From: Simon Davis
Sent: 04 February 2020 12:44
To: Andy Cooke [REDACTED]
Subject: RE: FP-171-18-PL

I agree that the decision was made in accordance with the plan which you attached to the email (17094-PL-2-07 RevD - Boundary Materials). This specifies that the boundary between the new houses and properties on Wellers Close should be a 1.8m high fence. However, the plan does not specify that a new fence is to be erected and if the existing fence is already 1.8m then there would be no breach of the planning permission. If however the existing fence is lower, then yes we would expect to see either a new fence erected or the existing one replaced to a height of 1.8m. If you consider that the boundary would then be too low, you could consider raising the fence or planting shrubs on your side to provide extra screening. You don't need planning permission for a boundary height of 2m but beyond that, permission would be required. However, no permission is required for planting. You may wish to approach the developer to ask if they will raise the fence.

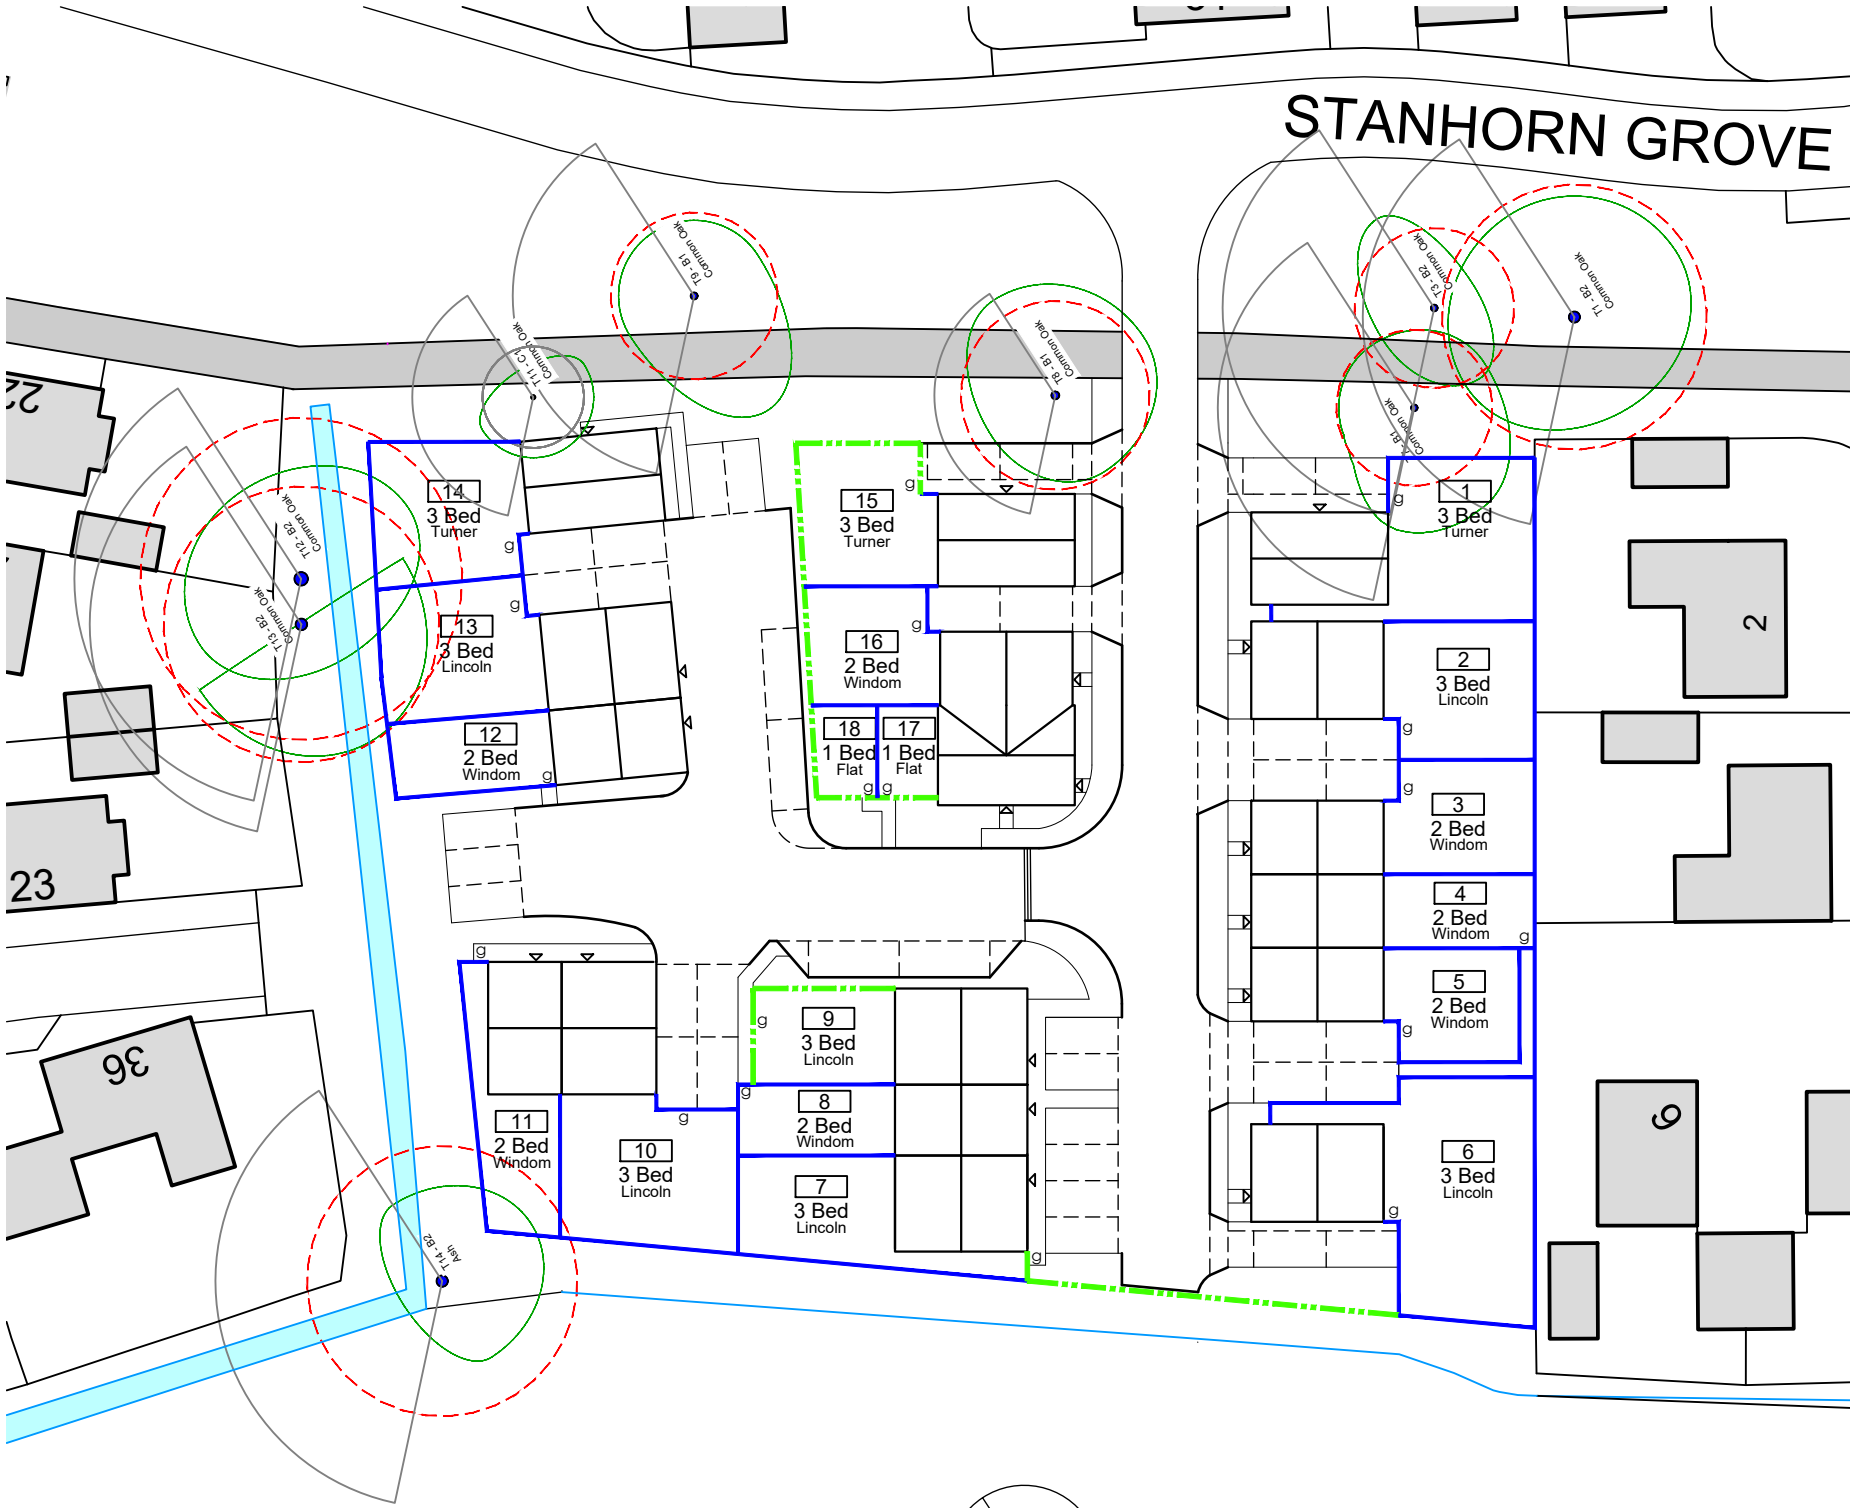
I understand following a conversation with the site manager that my boundary fence is now going to be used as the boundary for the new houses after having reassurance from the construction companies head office (Lauren Wiltshire) that this was not the case, I now understand that this is likely to be the case and that a construction company can deviate from the original plans.

I was led to believe that the gardens would be level with some form of retaining wall and a 1.8 metre boundary fence.

My main objections are that the gardens in the new properties will slop to meet with my fence, as the new properties are considerably higher than my property (600cm) a six foot fence becomes effectively a 4 foot fence. I have issues with privacy and the fact that I will look directly into the kitchens/living room of the new houses as they will be looking directly into my kitchen and drive.
